Harnett County Government Complex  
307 Cornelius Harnett Boulevard  
Lillington, NC 27546

July 13, 2007

Re: Status of Improvement Permit Application #07-5-17744  
Persimmon Hill Lt 65

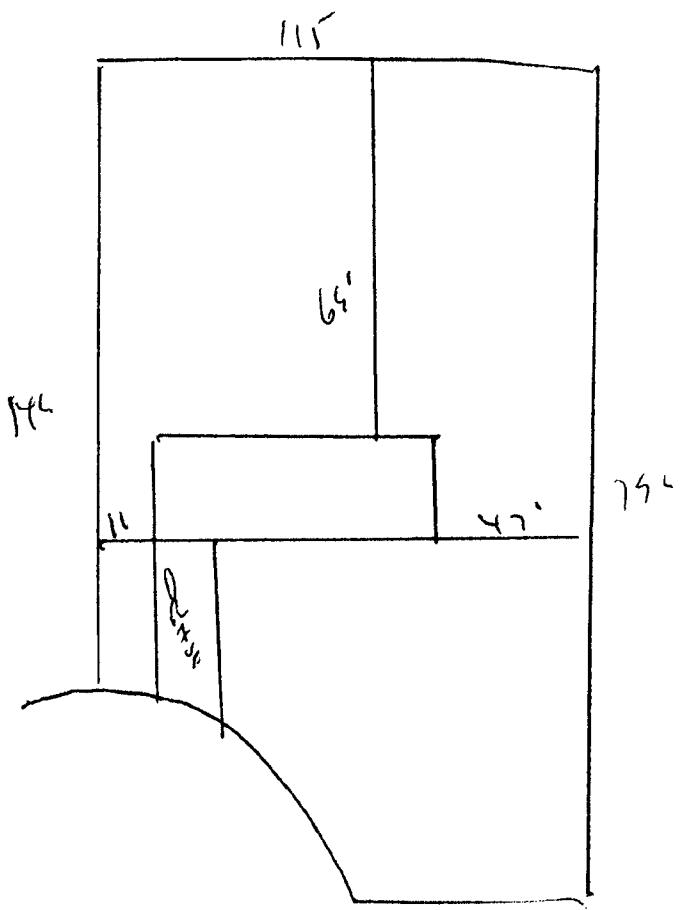
- 1. Property lines/corners not marked or labeled
- 2. House corners not marked or labeled
- 3. Directions not clear to property
- 4. Property needs brush or vegetation removed
- 5. Backhoe pits required
- 6. Other – Move house as shown on attached sheet.
